**Consultation Response from Alan Smith,
KC Waste Strategy (Refuse & Recycling)**

2025/91542 Land at, Highmoor Lane, Hartshead Moor, Cleckheaton, BD19 6LW

**Erection of 40 dwellings and associated works, including formation of new vehicular access
and erection of cricket netting**

The applicant has submitted Planning layout - Proposed Site / Block Layout [id 1093069] 20/06/2025 - 1002 - P2 Proposed Site Layout.

DRAWING NO
1002

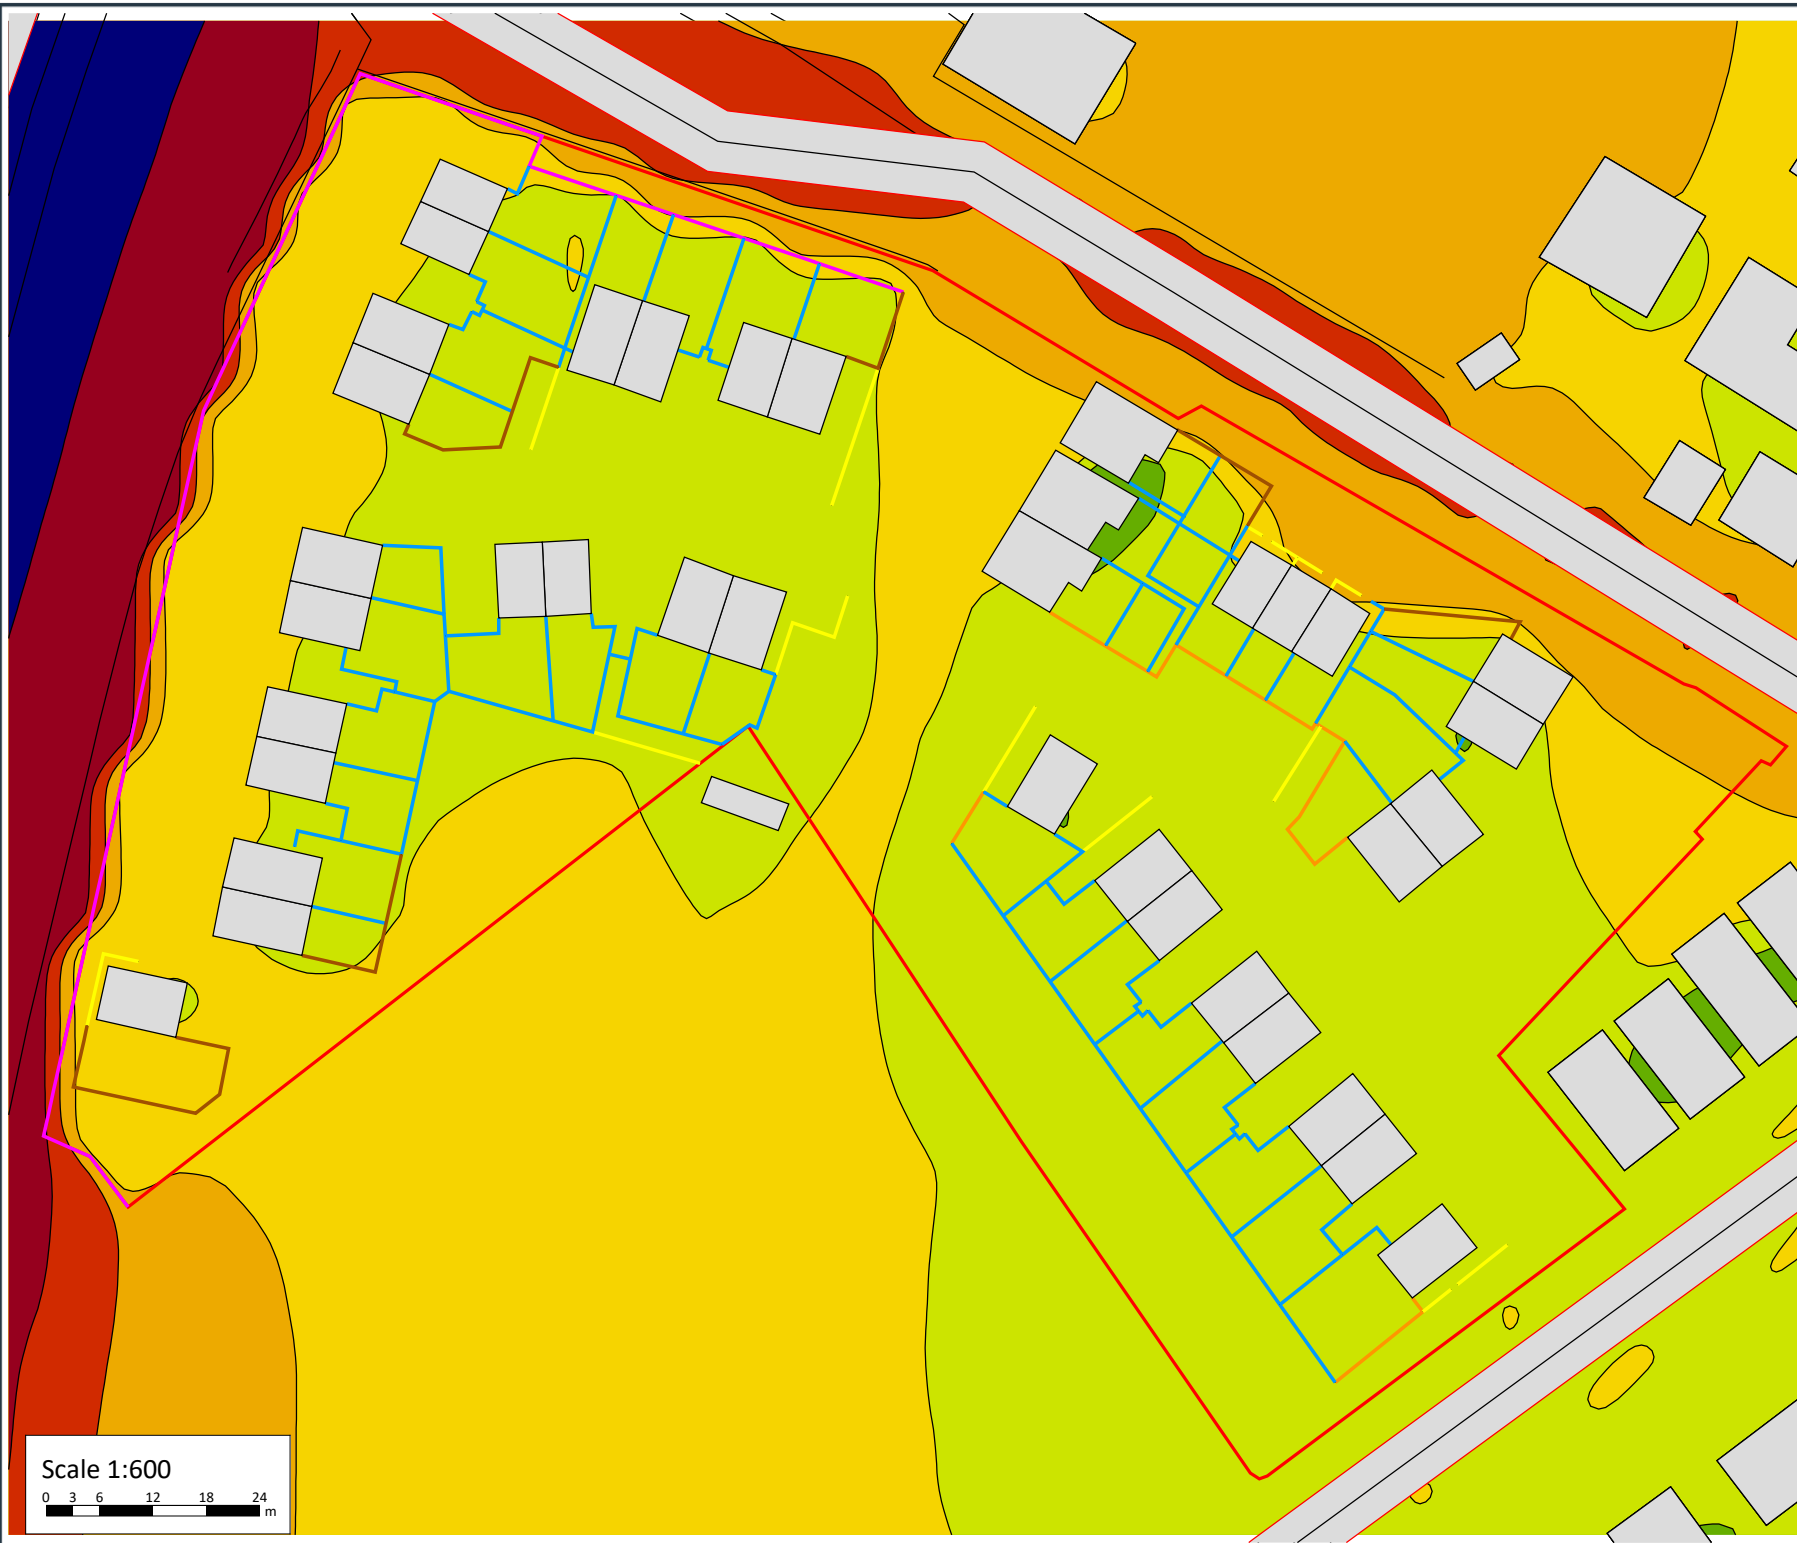
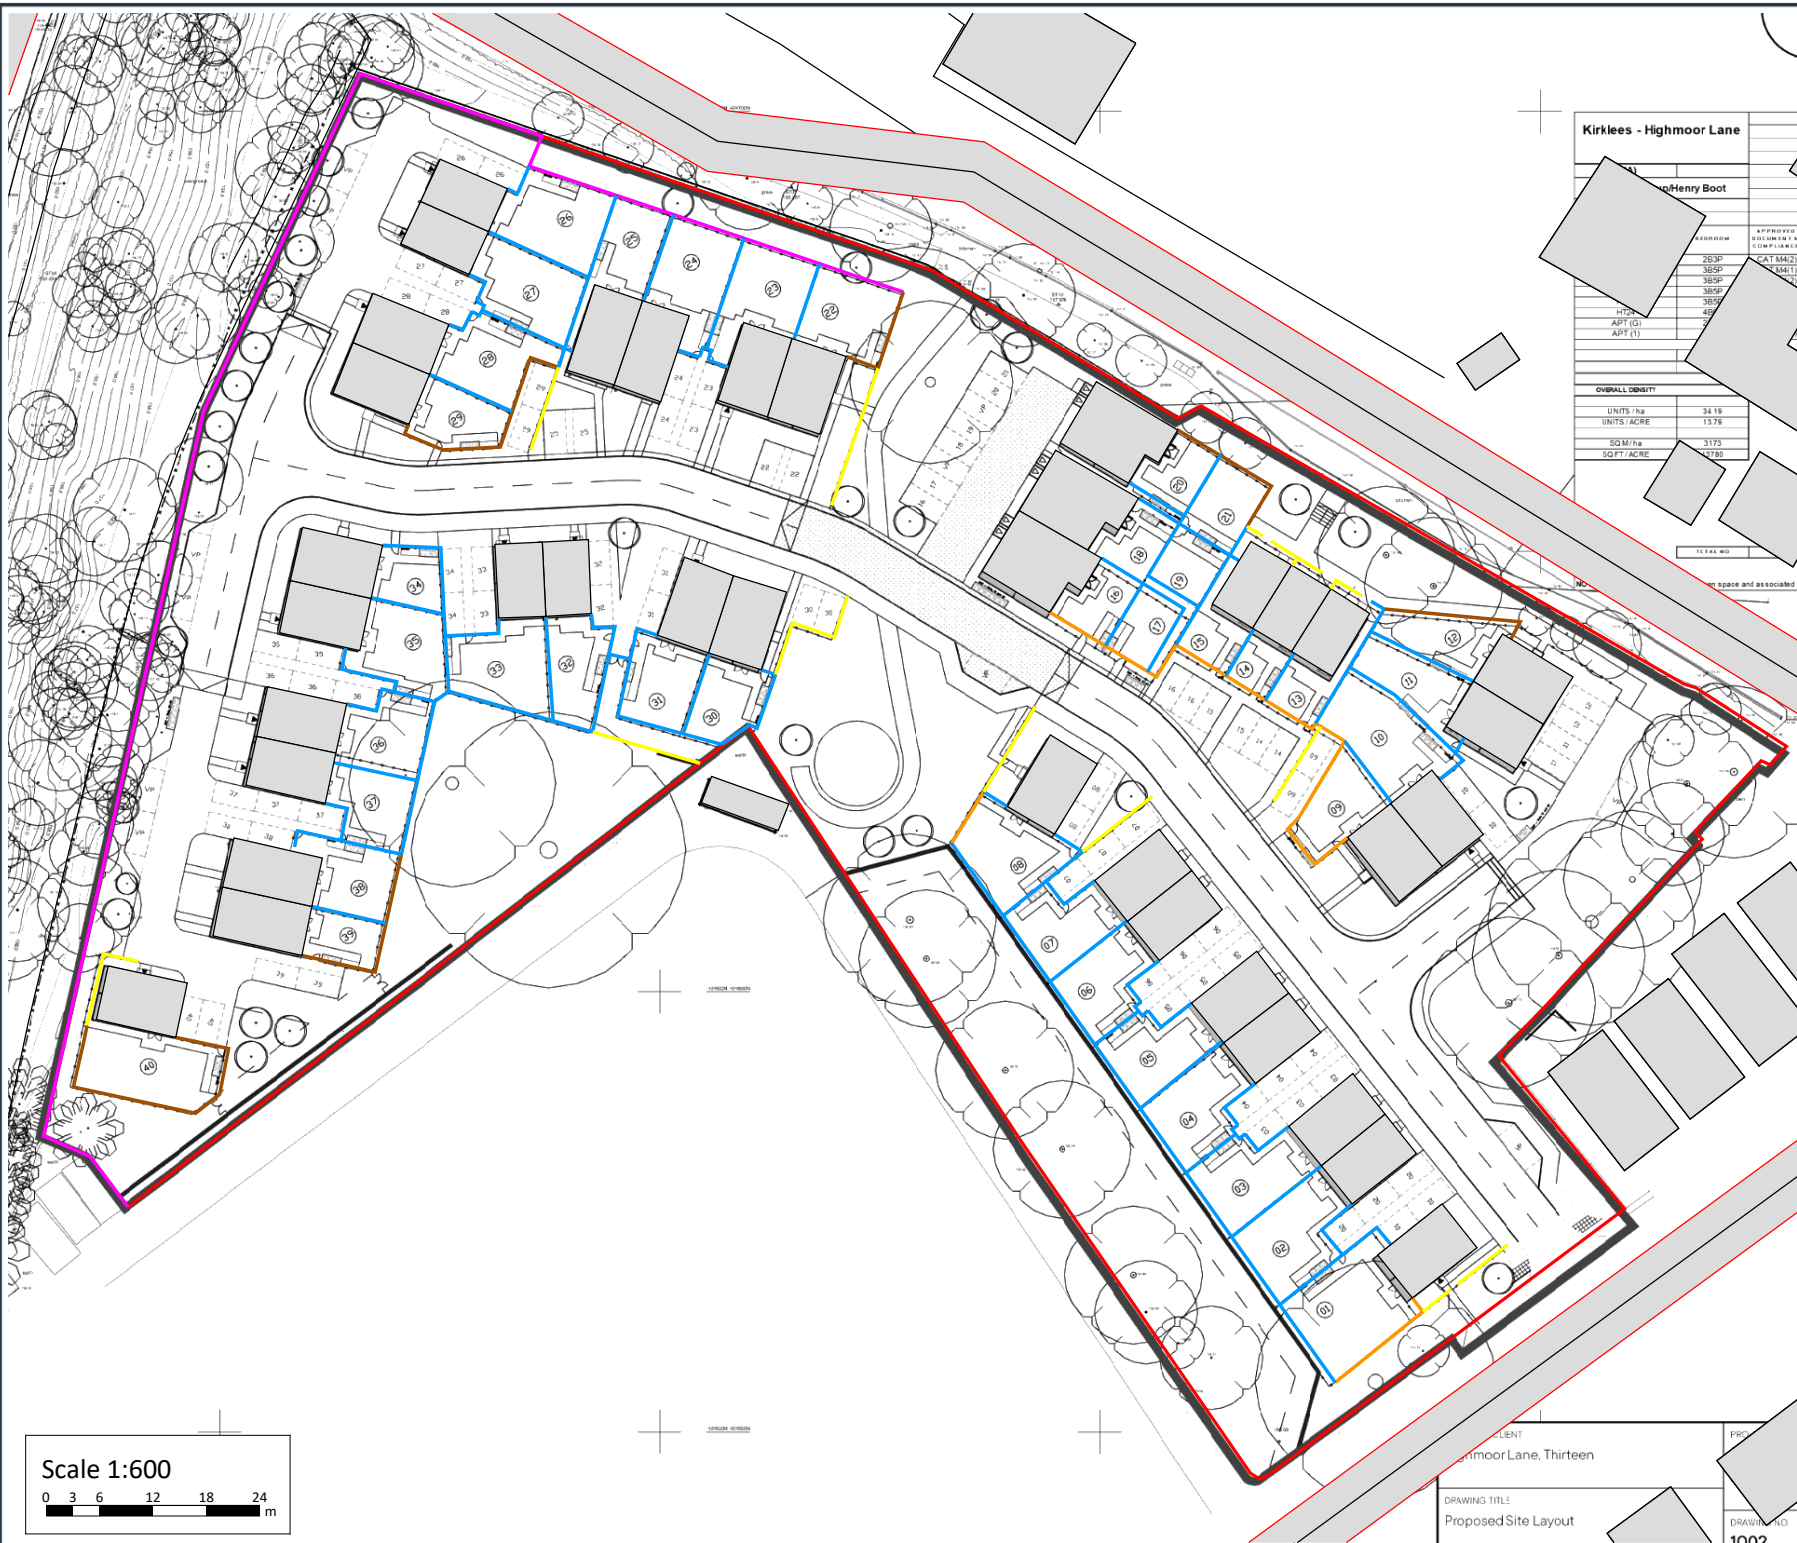
- It is welcomed the plan shows the storage location and collection points for 3 x 240ltr wheeled bins. The storage footprint for a 240ltr wheeled bins is 940mm x 780mm with enough room to allow removal of the bin from the storage location. The floor plan for storage must be large enough to accommodate 3 x 240ltr bins for each dwelling.

- It is important to ensure bins do not cause obstruction to pedestrians or other highway users when presented for collection, particularly where space requires these to be left in clusters. Bin Collection Points (BCP) are shown on the plan. Bin presentation space should be on a hard surface and where a refuse collection vehicle (RCV) can be easily reached.

- Plots 11 and 12 have a BCP which is over 24m away from the carriageway. I have marked on the plan a more suitable location for the BCP as this is within 15m of the carriageway. The drag out distance from the plots 11 and 12 would be about 35m. There is a danger the residents could leave their wheeled bins at the front of their property which is of concern to the Council. The options are to change the bin storage points or alternatively build a suitable bin storage area in the front of the plots to hold at least 3 x 240ltr bins. Storage to the front of houses should be screened and avoid wheeled bins being left adjacent to doors and under windows.

- Plots 16 and 17 have a bin storage point which leads directly to the carriageway. As the BCP for plots 13-15 is closest to these properties I would recommend increasing the size of this area to accommodate 5 x wheeled bins as it is likely that this location will be used.

- Plots 18, 19, 20 and 21 have a drag out distance from their properties to the BCP of over 30m. There is a danger the residents could leave their wheeled bins at the front of their property which is of concern to the Council. The options are to change the bin storage points or alternatively build a suitable bin storage area in the front of the plots to hold at least 3 x 240ltr bins. Storage to the front of houses should be screened and avoid wheeled bins being left adjacent to doors and under windows. The plan shows a potential site for bin storage area.

- For plots 26, 27 and 28 a new BCP is suggested to facilitate the fast and efficient collection of bins in the turning head, this is shown on the plan. For some residents this will mean a drag out distance from their properties to the BCP of over 30m. There is a danger the residents could leave their wheeled bins at the front of their property which is of concern to the Council. The options are to change the bin storage points or alternatively build a suitable bin storage area in the front of the plots to hold at least 3 x 240ltr bins. Storage to the front of houses should be screened and avoid wheeled bins being left adjacent to doors and under windows. The plan below shows a potential site for bin storage area.

- For plots 36, 37, 38, 39 and 40 a new BCP is suggested to facilitate the fast and efficient collection of bins in the turning head, this is shown on the plan. For some residents this will mean a drag out distance from their properties to the BCP of over 30m. There is a danger the residents could leave their wheeled bins at the front of their property which is of concern to the Council. The options are to change the bin storage points or alternatively build a suitable bin storage area in the front of the plots to hold at least 3 x 240ltr bins. Storage to the front of houses should be screened and avoid wheeled bins being left adjacent to doors and under windows.

- There is a turning head shown on the layout plan by plots 10, 29 and 36. Turning heads have a significant impact on waste collection operations. Where RCV's needs to turn around it is slows / adds to collection time which has a long-term impact on collection efficiency for the lifetime of the property compared to looped roads. Reversing is a recognised safety risk for crews and pedestrians. **The Waste Industry Safety and Health (WISH) Forum guidance states "Reversing causes a disproportionately large number of moving vehicle accidents in the waste/recycling industry. Injuries to collection workers or members of the public by moving collection vehicles are invariably severe or fatal. BS 5906: 2005 recommends a maximum reversing distance of 12 m."**

- Where turning is necessary, the turning facilities must be demonstrably sufficient for an 11.22m refuse collection vehicle. **Active measures should be taken to prevent parking in the turning head as otherwise an RCV would have a very long reverse manoeuvre which is a recognised safety risk and is not acceptable.**
